**New Request for Advice – Liverpool Hospital Redevelopment
(SSD-10389) (Liverpool City)**

TAB A – TfNSW Comments – SSD 10389 EIS Liverpool Hospital Redevelopment

DRAWING	PRINT DATE
GROUND PLAN	5/11/2020

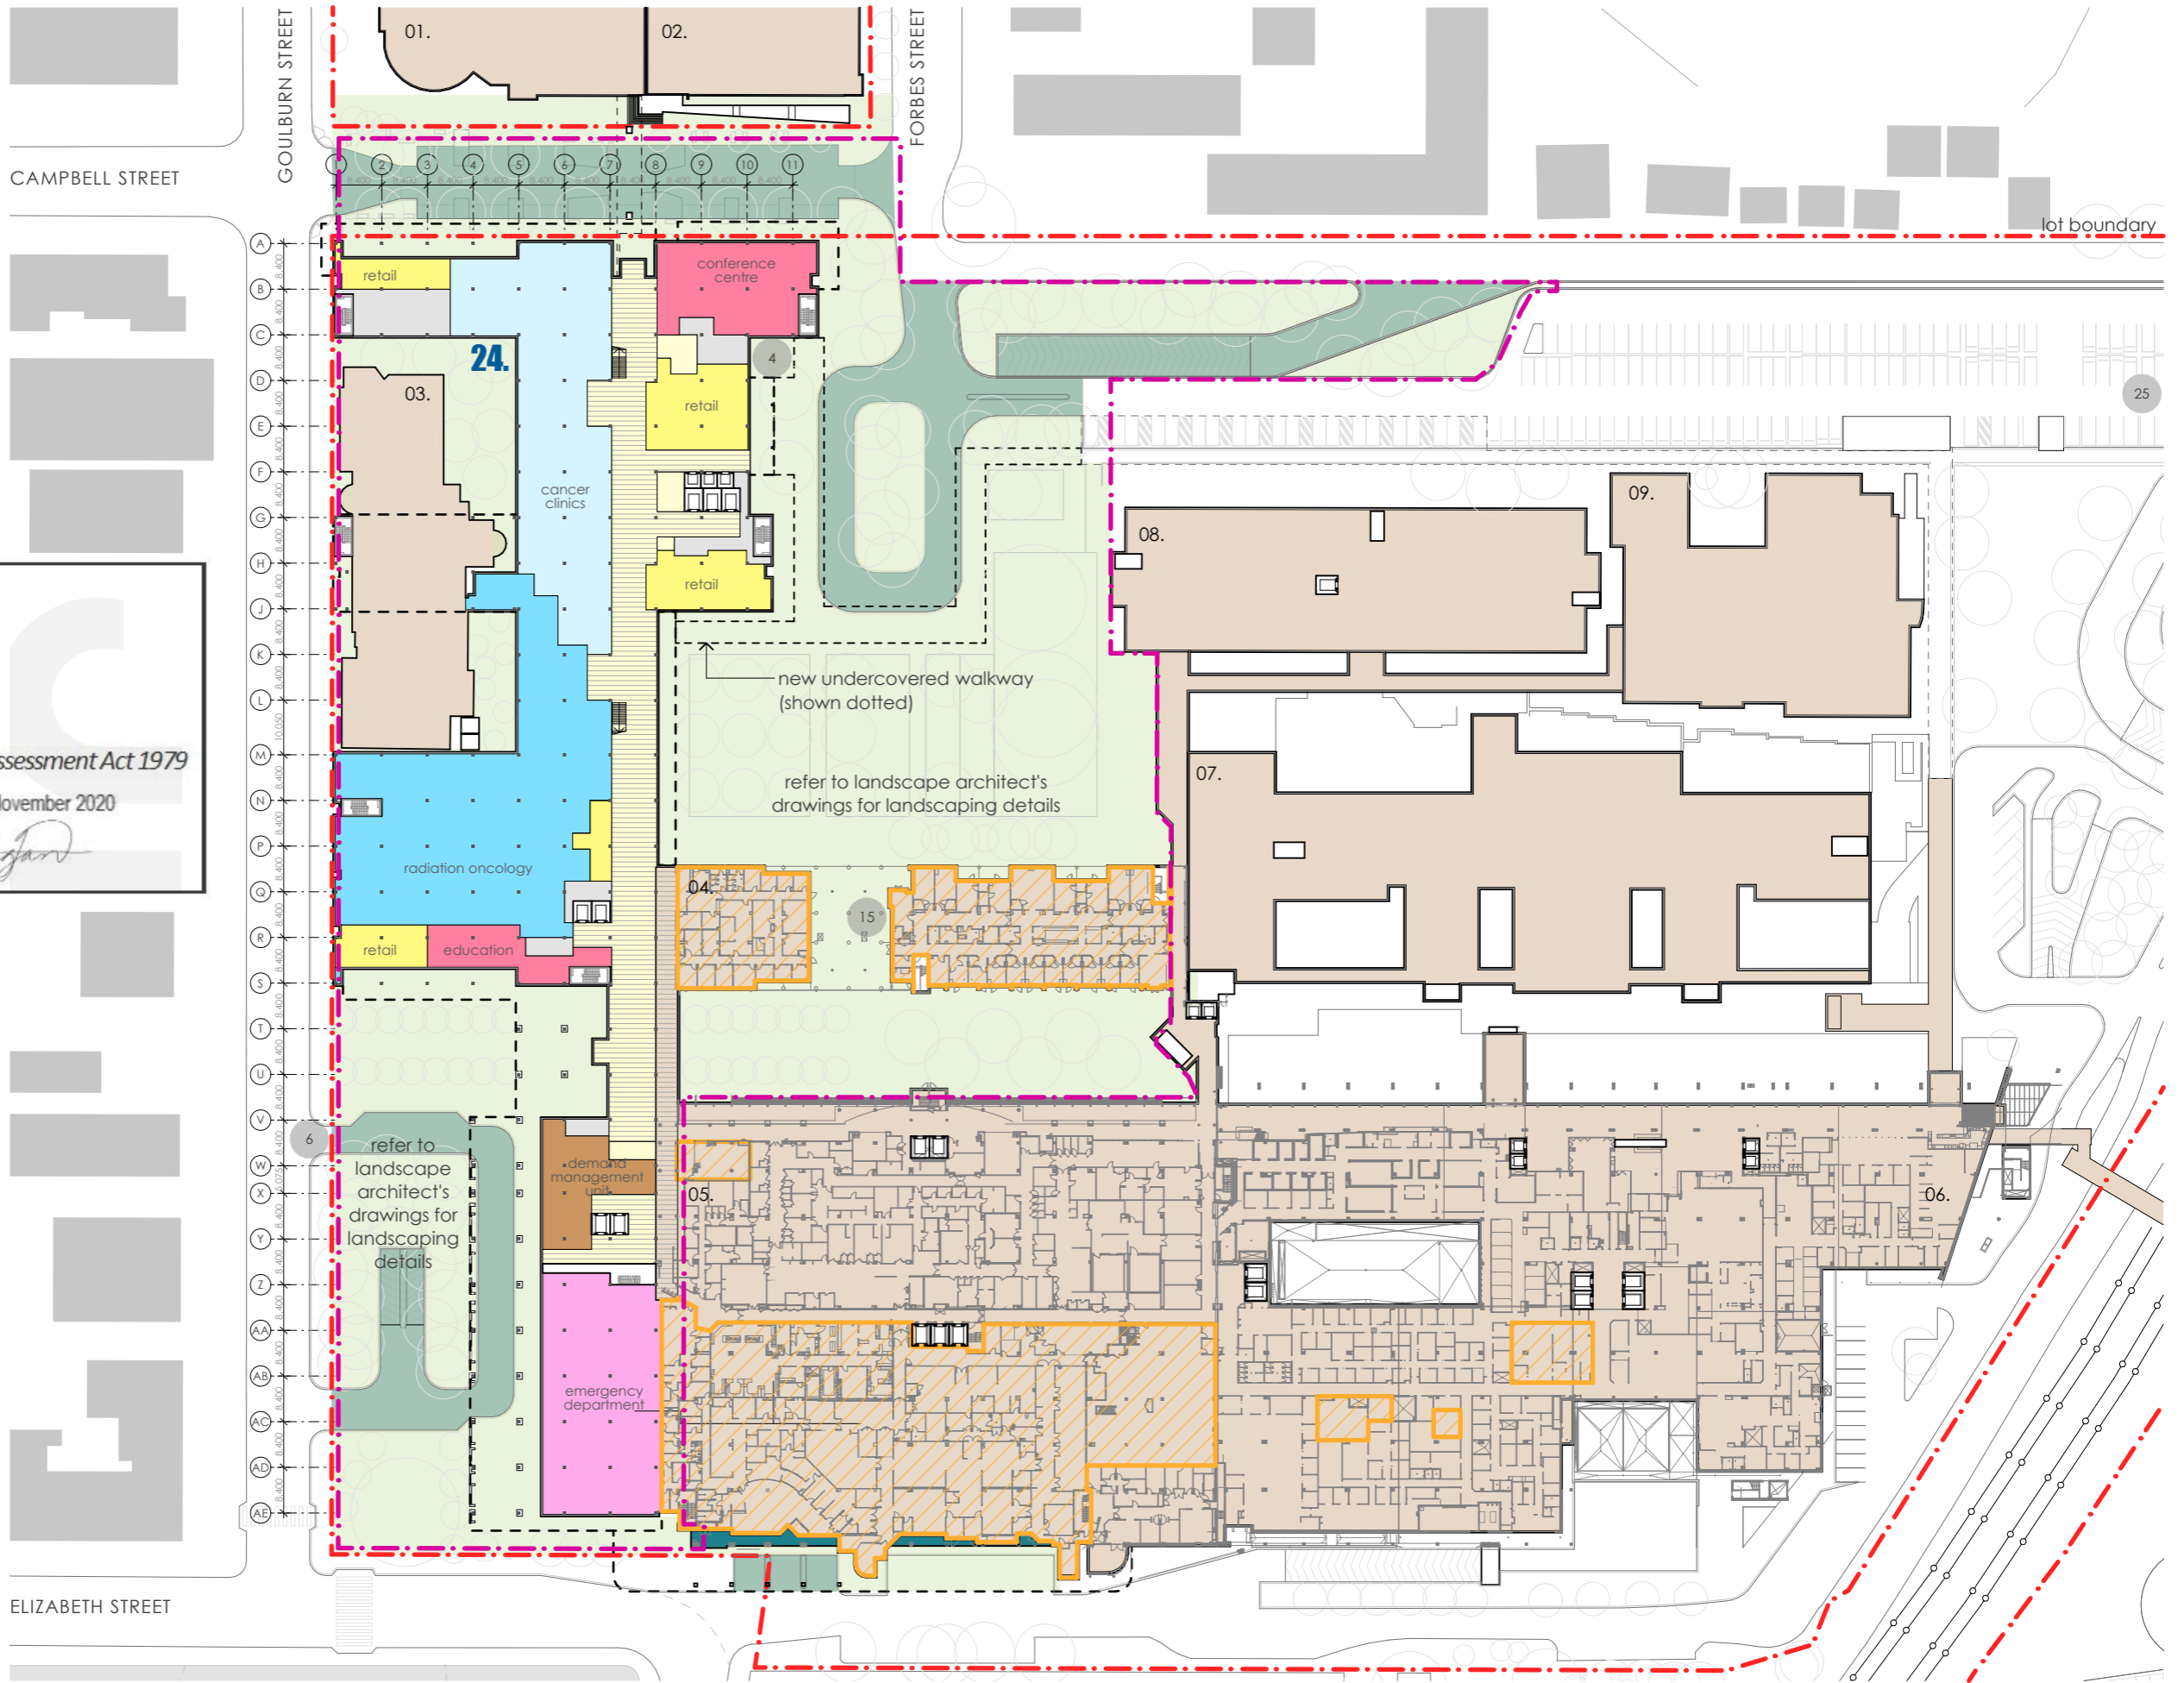
- There is an opportunity for the TIA to be updated to comprehensively address the likely demand for bicycle parking similar to the car parking analysis.
- Walking is mostly referred to in the report as a trip mode for people living close by. However, walking would be the second likely option for visitors and staff who do not have cars or choose to use public transport. Similarly, the report lacks detailed analysis regarding the likely demand for cycling infrastructure such as bicycle parking (as noted above) and end of trip facilities following the hospital redevelopment.

- Any needed improvements to pedestrian connectivity and accessibility to Liverpool and Warwick train stations following the redevelopment;
- Detailed analysis of the likely demand for cycling infrastructure including bicycle parking and end of trip facilities following the redevelopment; and
- Off-street bicycle parking and end of trip facilities to Liverpool Council requirements as outlined in their DCP 2008 Part 1.

Prior to the issue of the first Occupation Certificate, off-street bicycle parking spaces and end of trip facilities are to be provided in accordance with the Liverpool Council DCP 2008 Part 1 and in accordance with AS2890.3.
